Recommendation Report for Planning Permission for Works or Extension to a Dwelling

REF NO: AW/235/18/HH

LOCATION: 61 Queens Fields West
Aldwick
PO21 5SH

PROPOSAL: First floor extension.

sheet 2 of 3

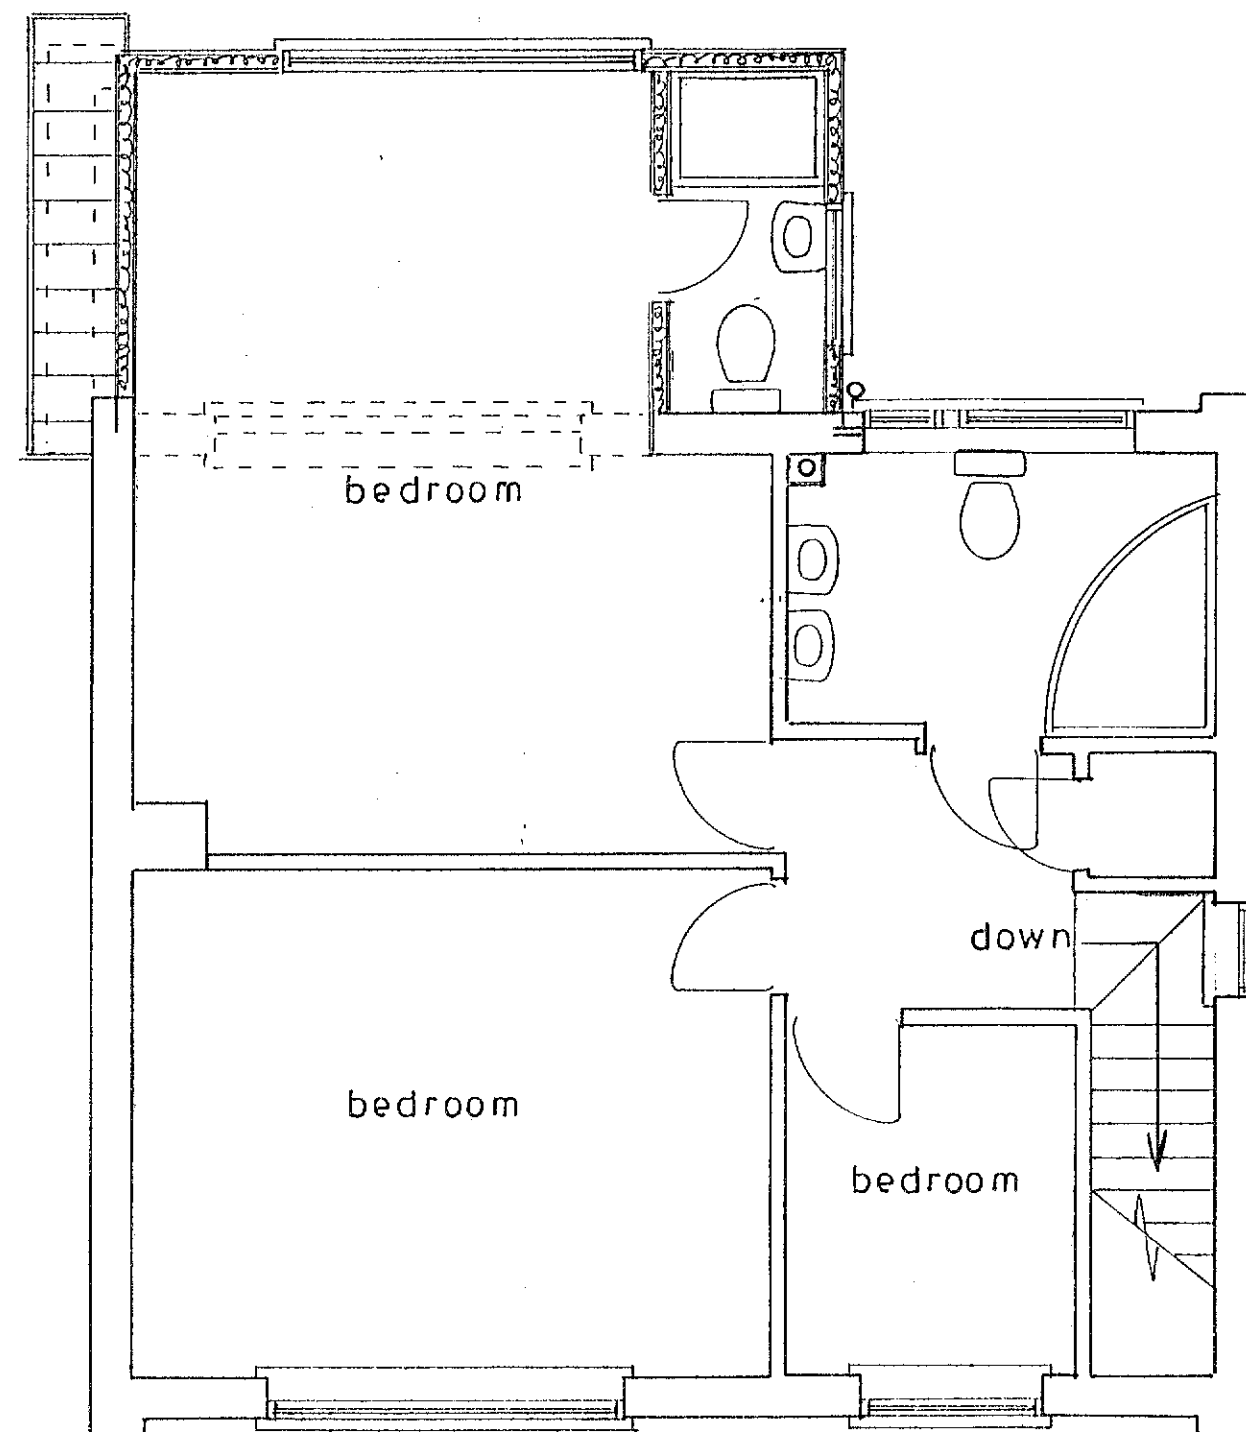
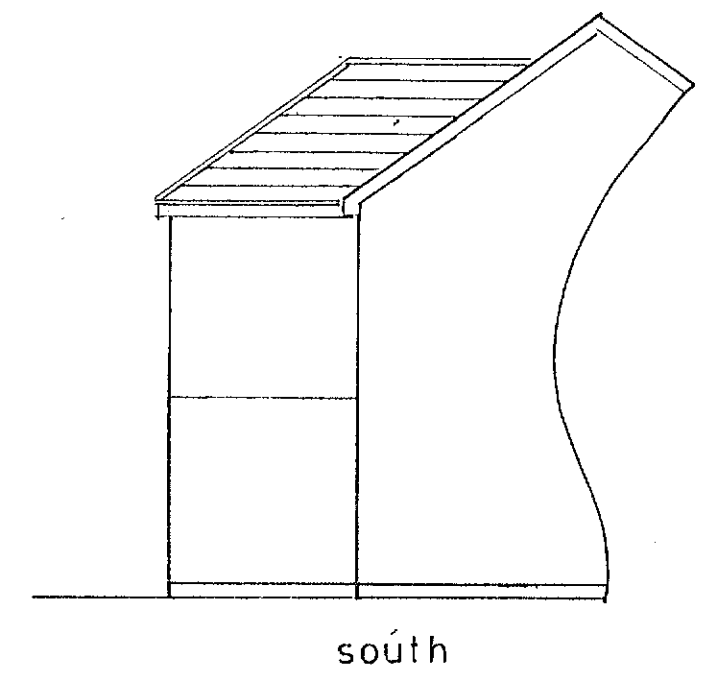
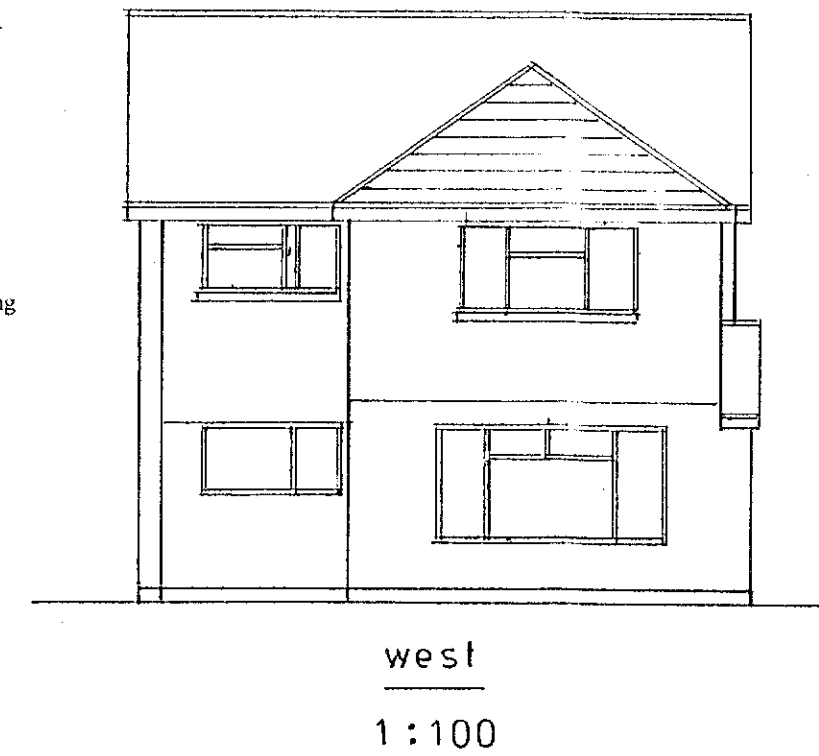
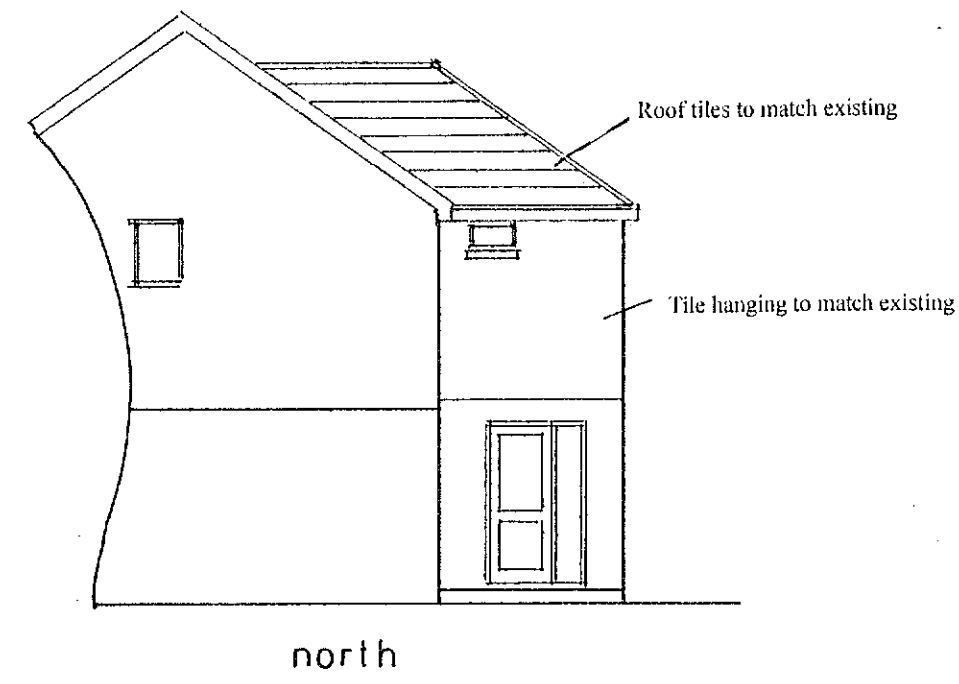
The existing single storey rear extension currently stands at 4m in height. The addition of a first floor extension will increase the height to approximately 7.2m. It will be constructed with a pitched roof and sit around 0.75m below the ridge height of the host dwelling. The extension has a depth of around 2.4m.

Due to the siting of the host dwelling, the proposal does not extend beyond the rear wall of the neighbouring property to the south and therefore does not appear overbearing or give rise to any adverse overshadowing. The proposal also retains 5.1m separation to the boundary to the north which is considered sufficient to prevent any adverse impacts upon this elevation.

There will be 1 window installed to the rear and whilst this would give rise to some overlooking to the southern and western elevation, overlooking is already possible from the existing first floor window and it is not considered that it would increase significantly from that which is already possible.

A window will also be constructed to the first floor north elevation. Whilst it serves a bathroom there may be potential for views over the neighbouring property and as such it will be conditioned to be obscured glazed in order to prevent the potential for overlooking at this elevation.

- 3 The bathroom window on the first floor north elevation of the building shall at all times be glazed with obscured glass and only openable at least 1.7m above finished floor level.
